Your Ref: 23/01316/F

Erection of 5 two storey age restricted dwellings (55 years) for older people with access, landscaping and associated infrastructure - Land South of Faraday House, Woodway Road, Sibford Ferris (Application No. 23/01316/F)

I am part of a large group (over 165 members) of local residents living in Sibford Ferris and Sibford Gower - the Sibford Action Group ('Action Group') - and write to strongly object to the latest and current planning application (23/01316/F) for 5 no. age-restricted dwellings on land south of Faraday House, Woodway Road, Sibford Ferris ('the site') for the reasons set out in this letter.

Sibford Ferris
 OX15 5QW
 Plot 02
 Elevations

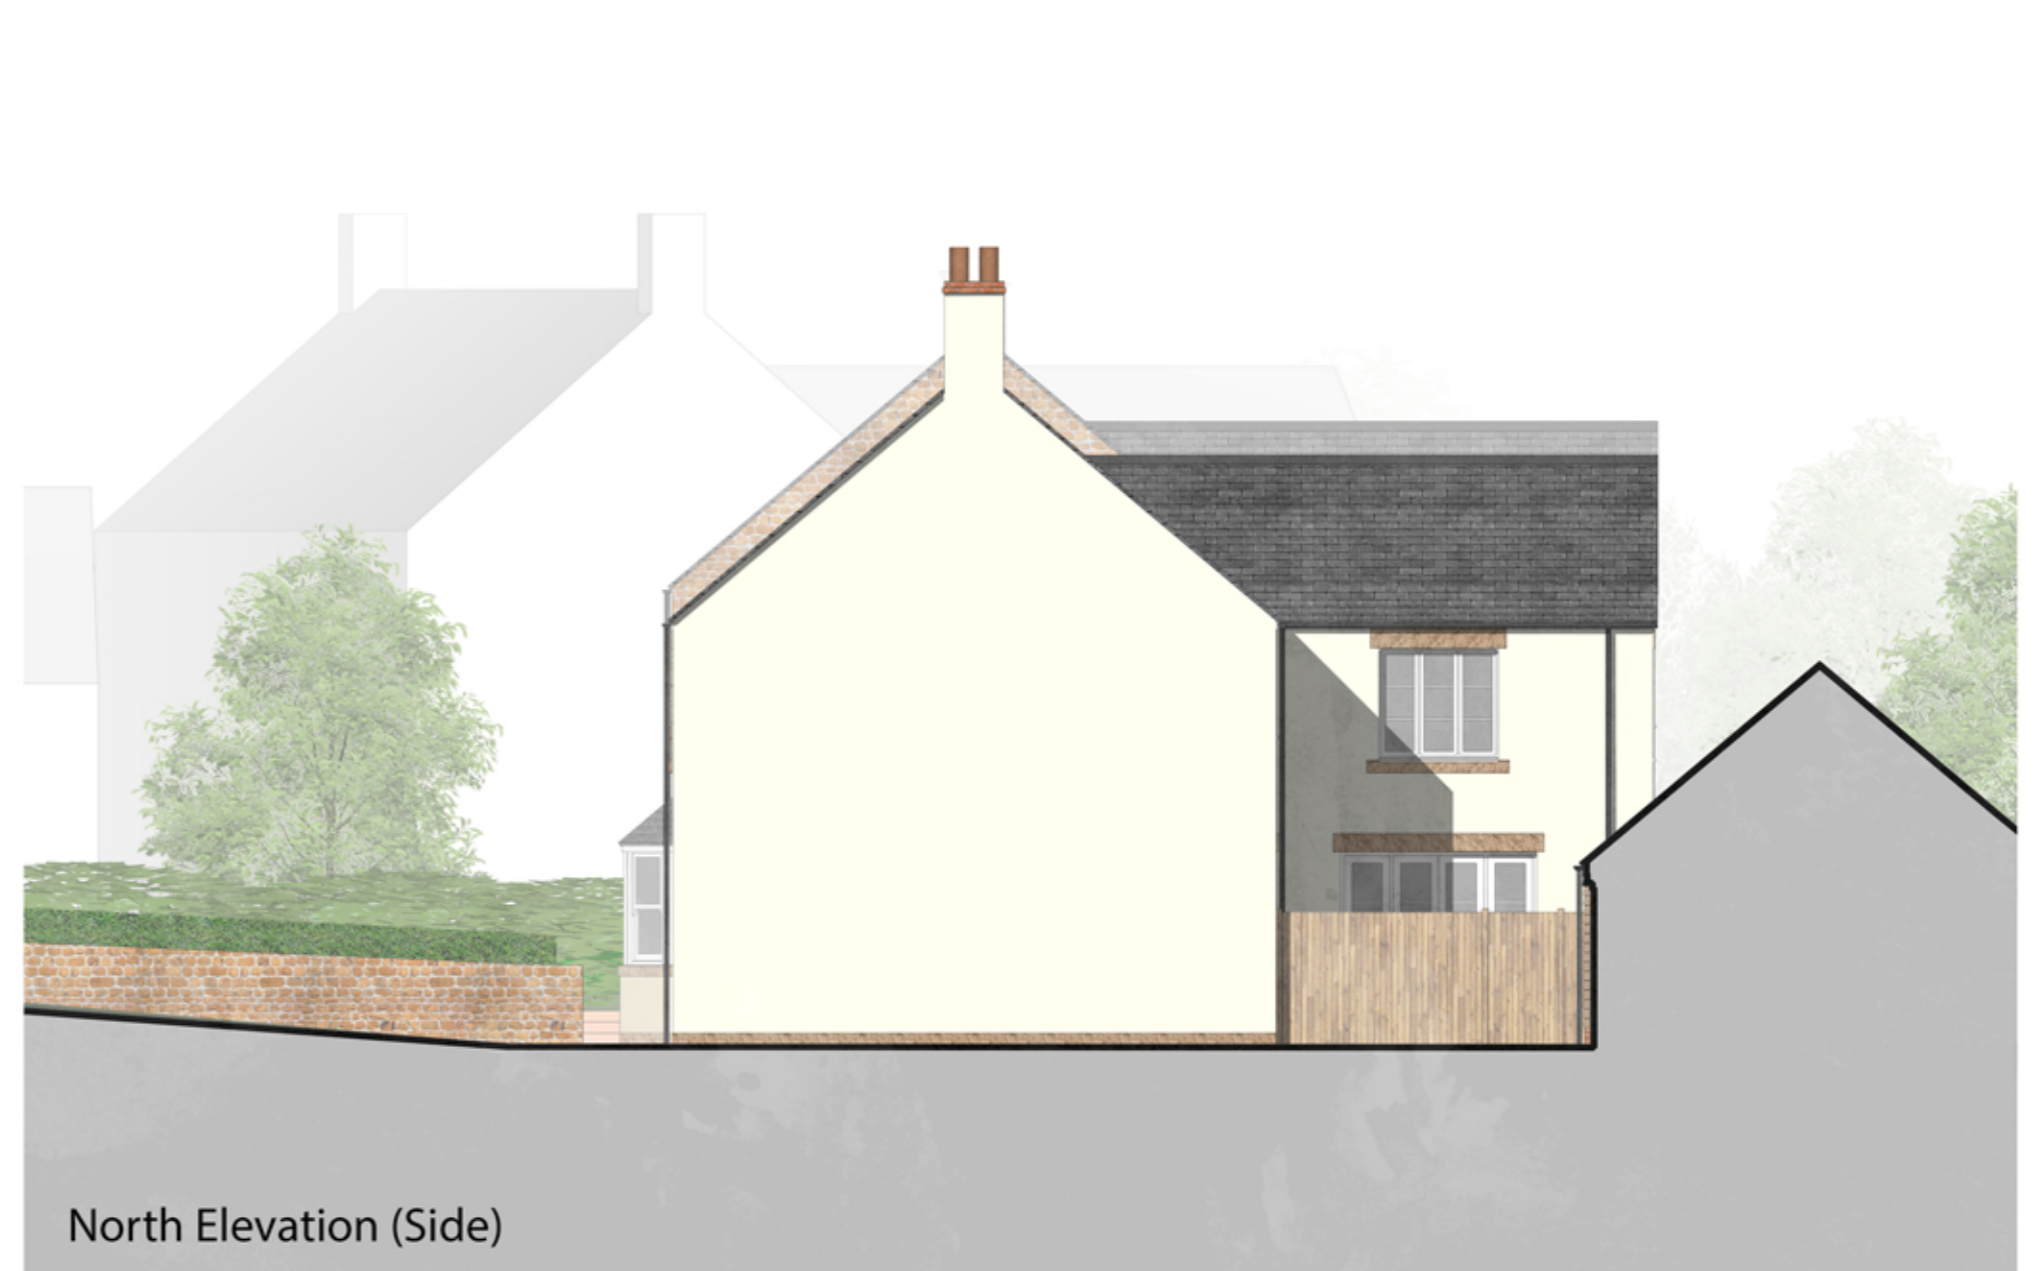
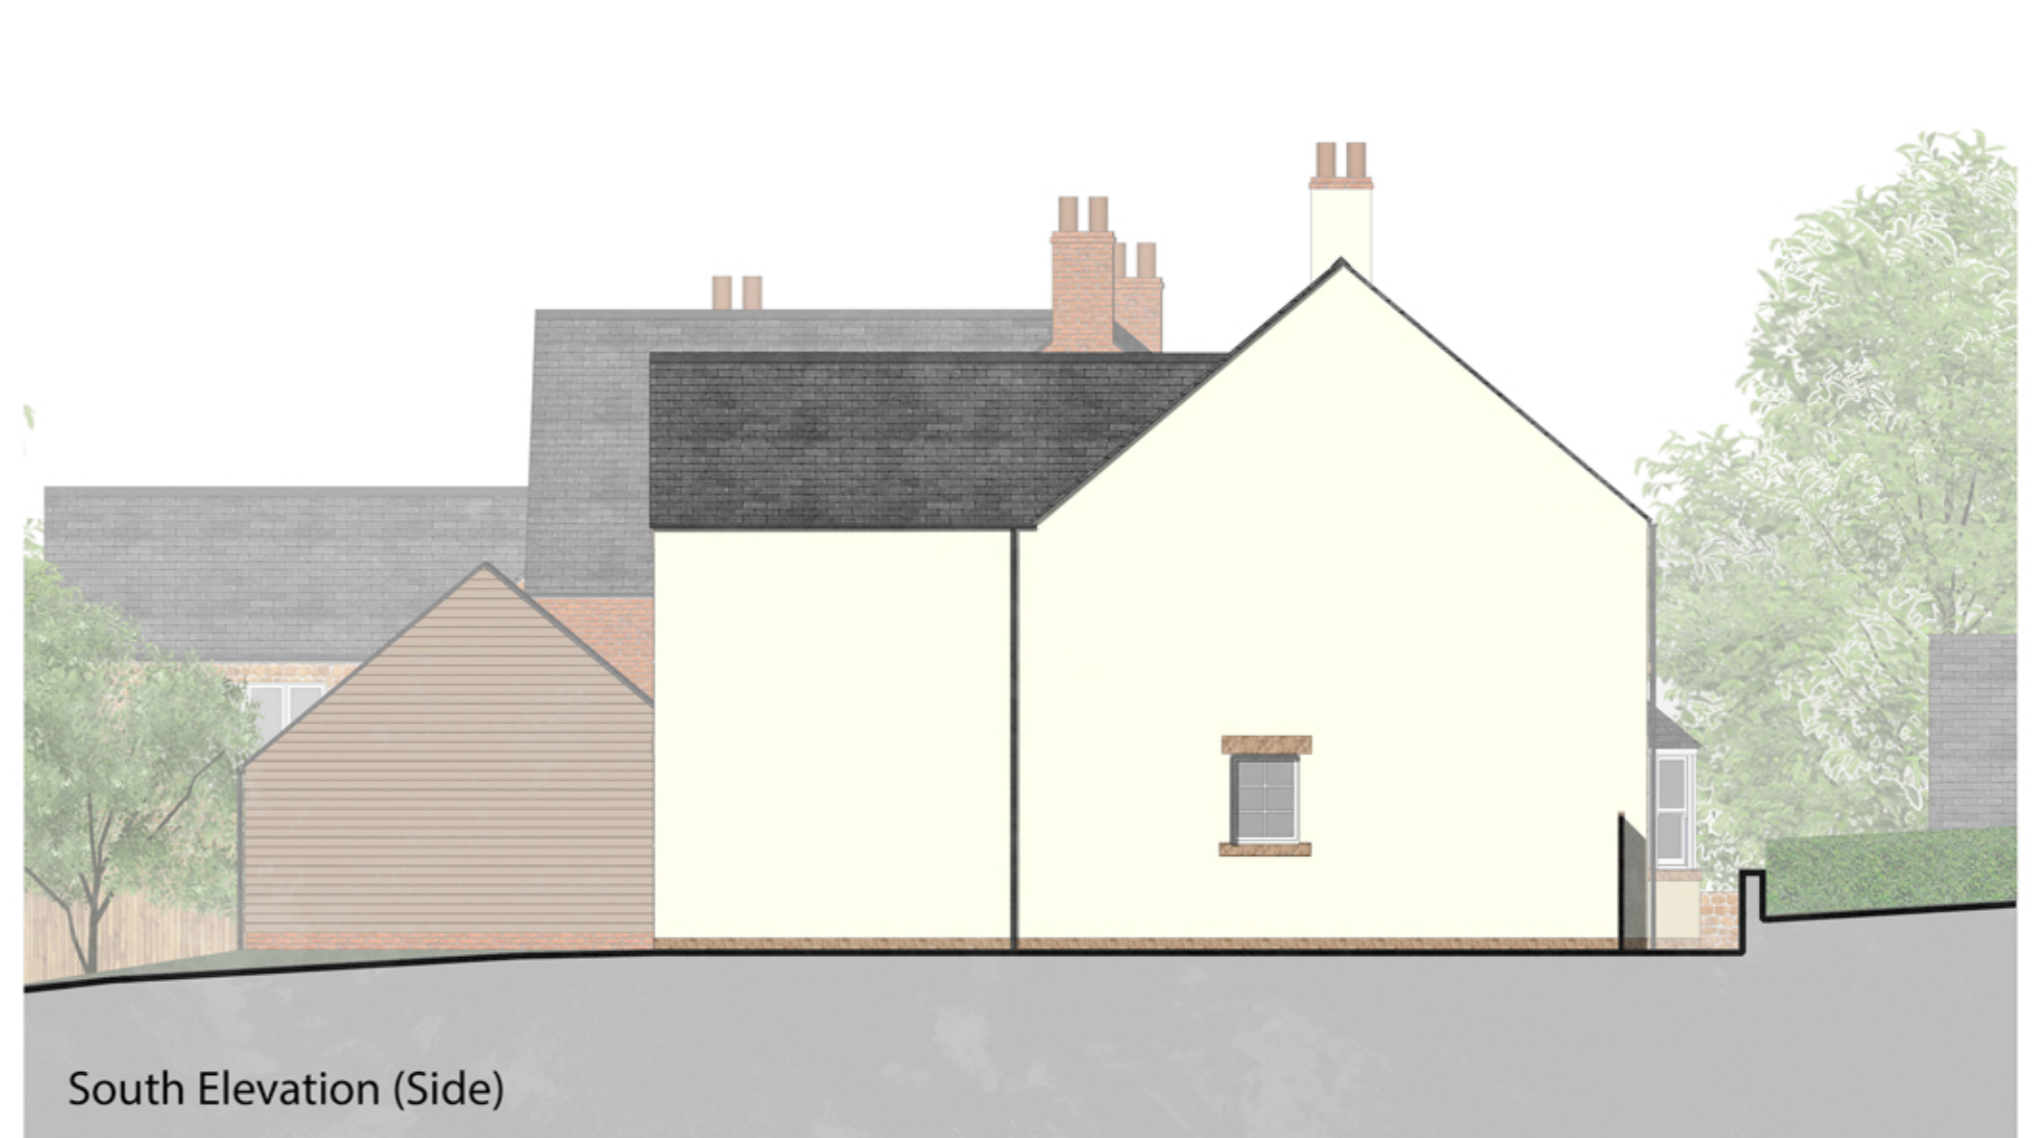
The physical impact of the dwellings – especially Plot 5 – is perhaps most acute upon Faraday House just 15 metres to the north of the site, as shown on Figure 6 taken from the application.

**SWEPT PATH ASSESSMENT**  
**11.18m REFUSE VEHICLE**

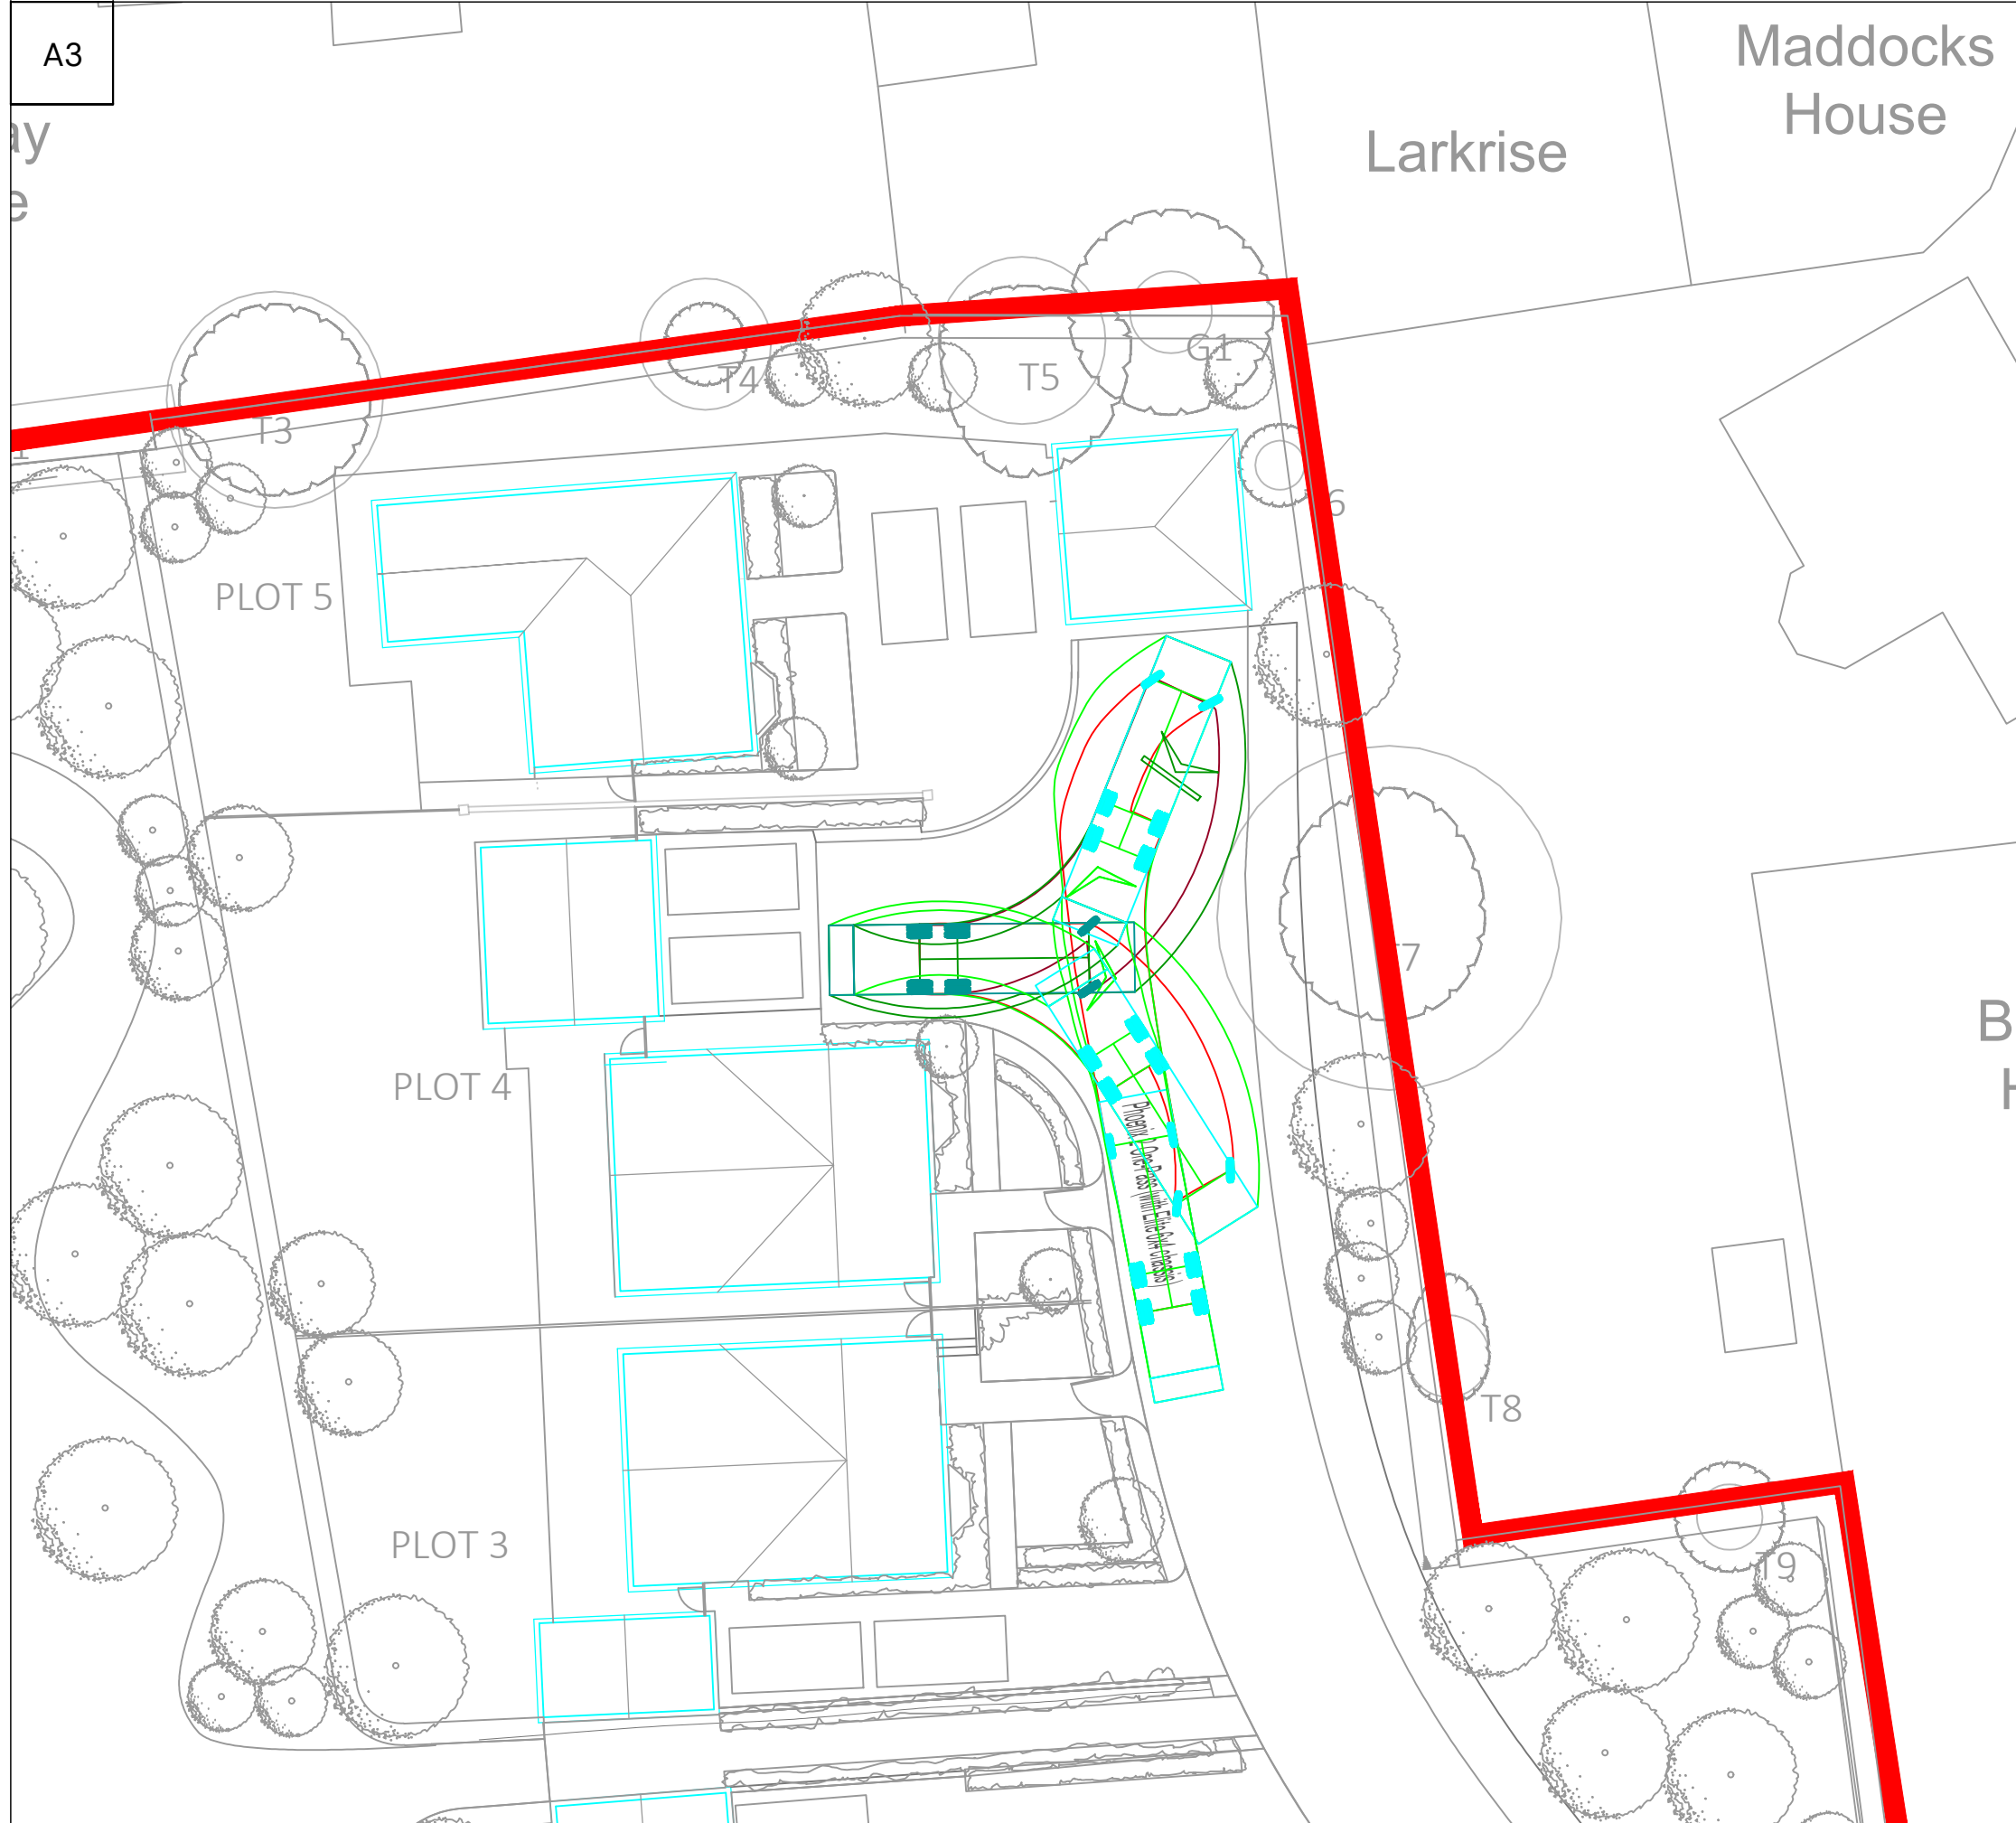
In this particular case, the amended proposal with two-storey dwellings will be accessed via what will become a long access road (circa 225m) serving a total of 30 no. dwellings (i.e. the proposed 5 no dwellings and the 25 no dwellings at Hook Norton Road) running within just a few metres of the private rear gardens of existing dwellings at Woodway Road, Stewart’s Court and Hook Norton Road. The use of this by residents’ vehicles, visitors and service vehicles will cause noise, disturbance and intrusion into what is presently open, rural countryside with very quiet ambient noise levels, which will be detrimental to the tranquil, peaceful residential amenities of existing neighbouring properties.
